From: Nolan, Chris <Chris.Nolan@lancashire.gov.uk>
Sent: 20 October 2017 09:23
To: Harriet McCartney; planning
Cc: LHS Customer Service
Subject: D3.2017.0879 - 12 Darkwood Crescent Chatburn

Planning Application No: 3/2017/0879

Proposal: Demolition of existing outbuilding and construction of two storey extension to gable and formation of driveway to front.

Location: 12 Darkwood Crescent Chatburn BB7 4AL

Proposed Site Plan 1:250

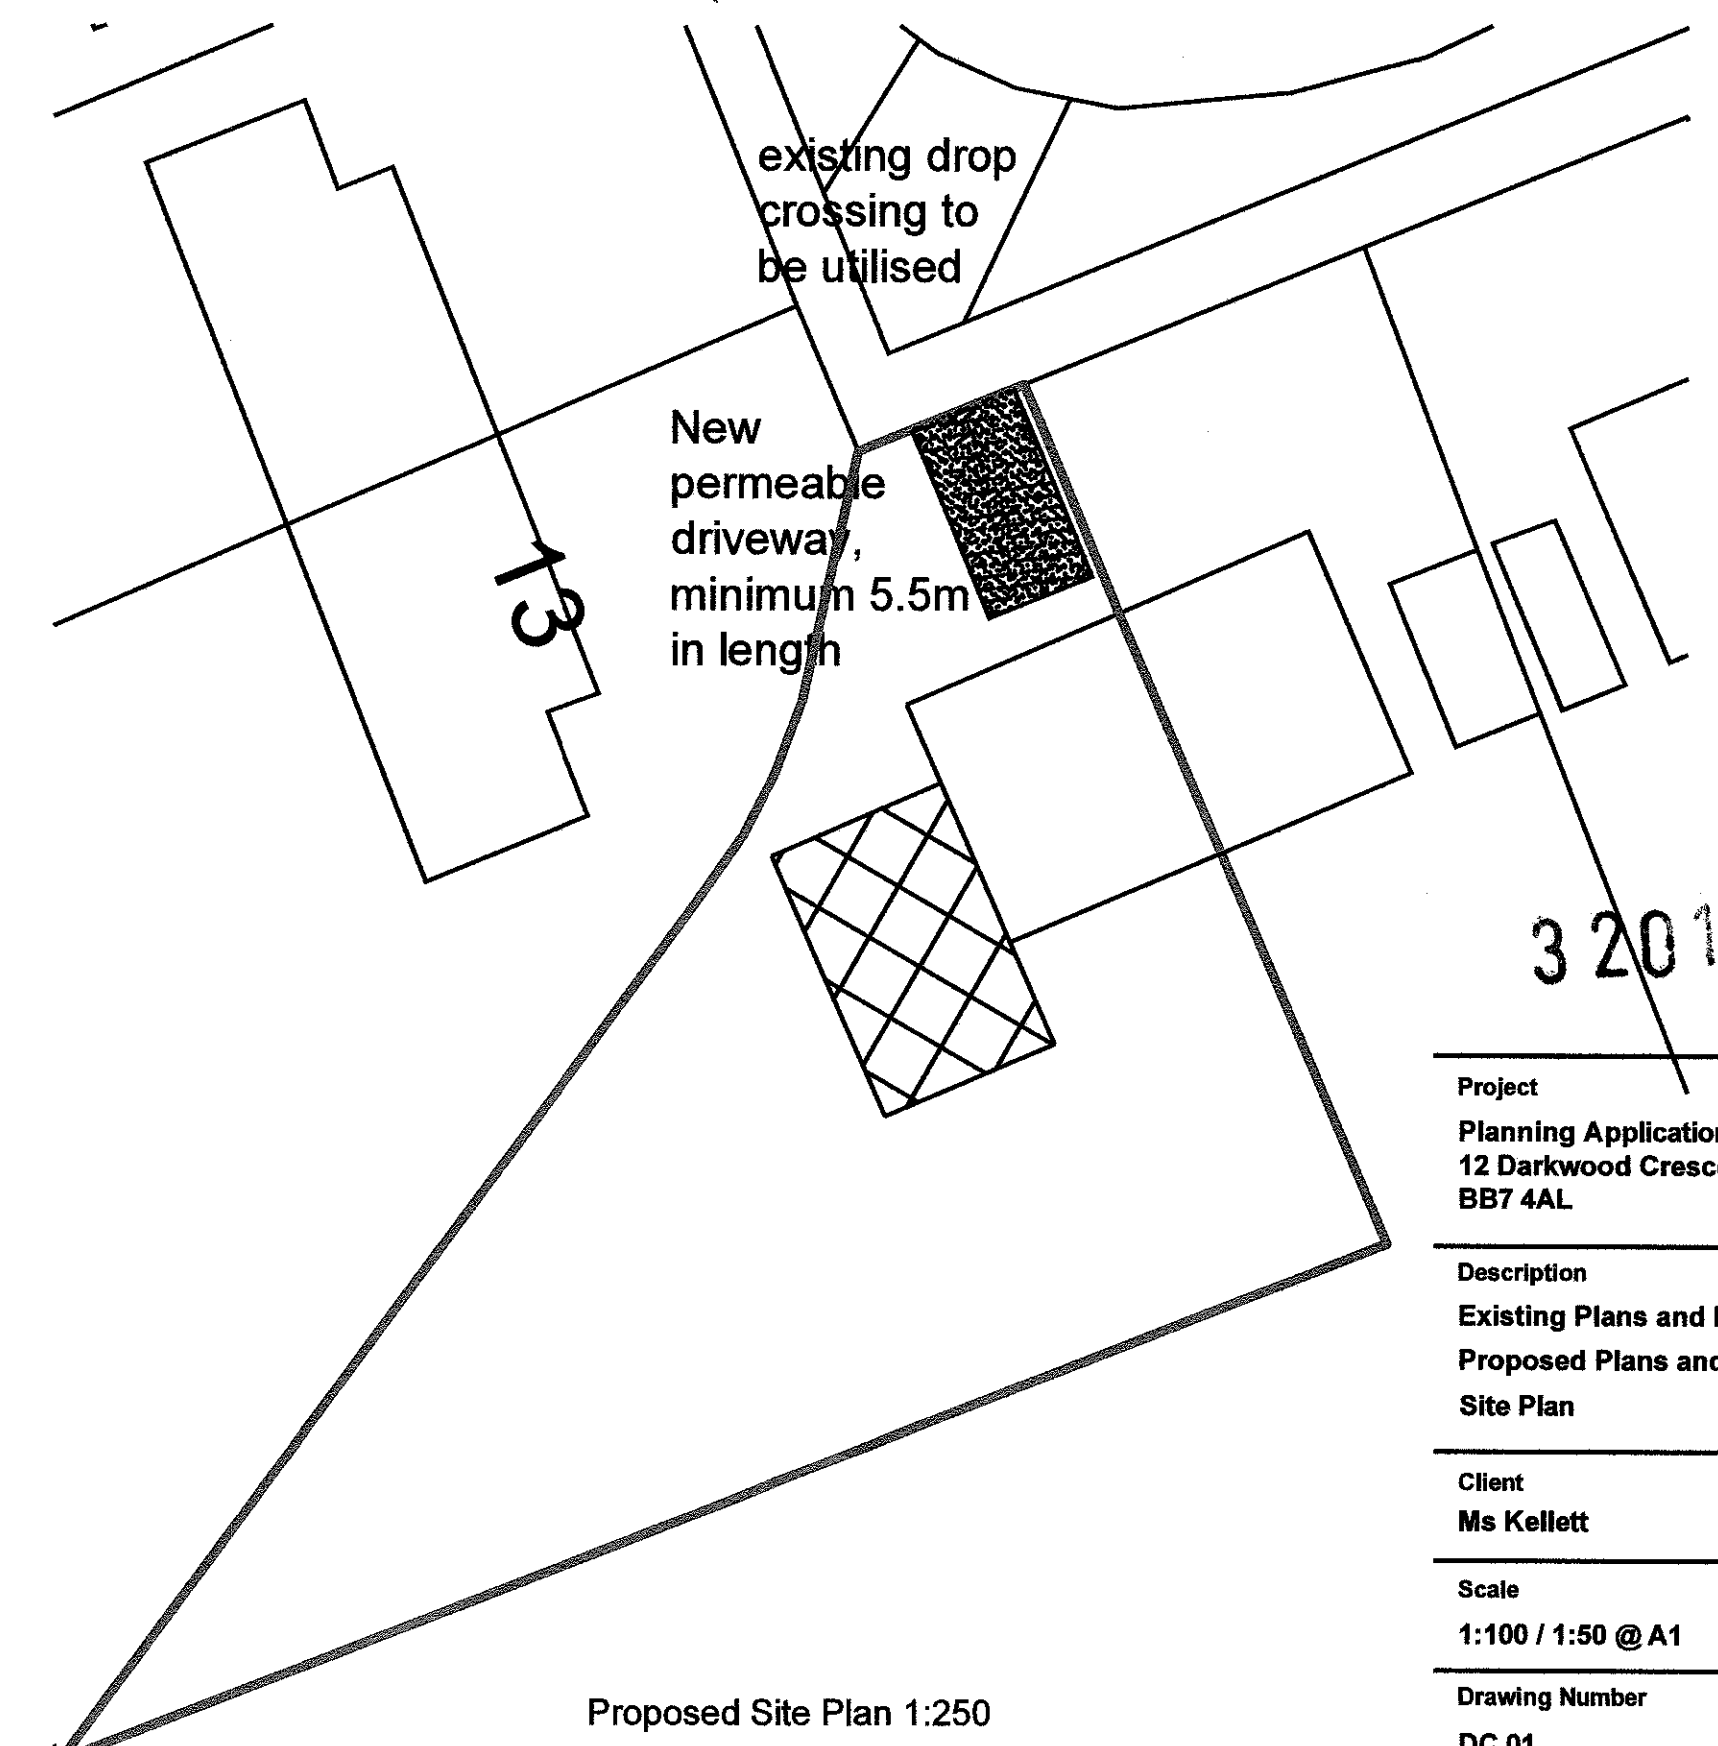
With regard to the above planning application to demolish an out building and to erect a two story extension that will increase the number of bedrooms in the dwelling from three to four. Normally I would be looking for such a house to provide three parking spaces. Presently the house is using "on street parking" to accommodate the requisite two parking spaces. The extra bedroom would raise the parking requirement by one parking space. As the plans indicate that this extra space will be within the curtilage of the property I would consider that the change in parking requirements have been provided. I would not have highway issues with this application as long as the indicated provision of one parking space within the curtilage of No.12 Darkwood Crescent is created prior to the occupation of the extension.

It should be noted that the formation of the parking bay will use the existing vehicle access for the most part but the plans do indicate that the vehicles will be crossing a section of footpath that has not previously been subject to this traffic. As this is the case the footpath may not have been constructed to sufficient standards. I feel that the client will need to have this checked by the county council prior to the formation of the parking bay.

1. No part of the extension hereby approved shall be occupied until the additional parking provision has been constructed and completed in accordance with the scheme details agreed by the LPA. Reason: In order the parking standards for the size of dwelling are met.
2. No building materials associated with the development hereby approved shall be stored or placed on the adopted highway network prior to, during and following completion of construction of the proposed works. Reason: In the interest of highway safety.
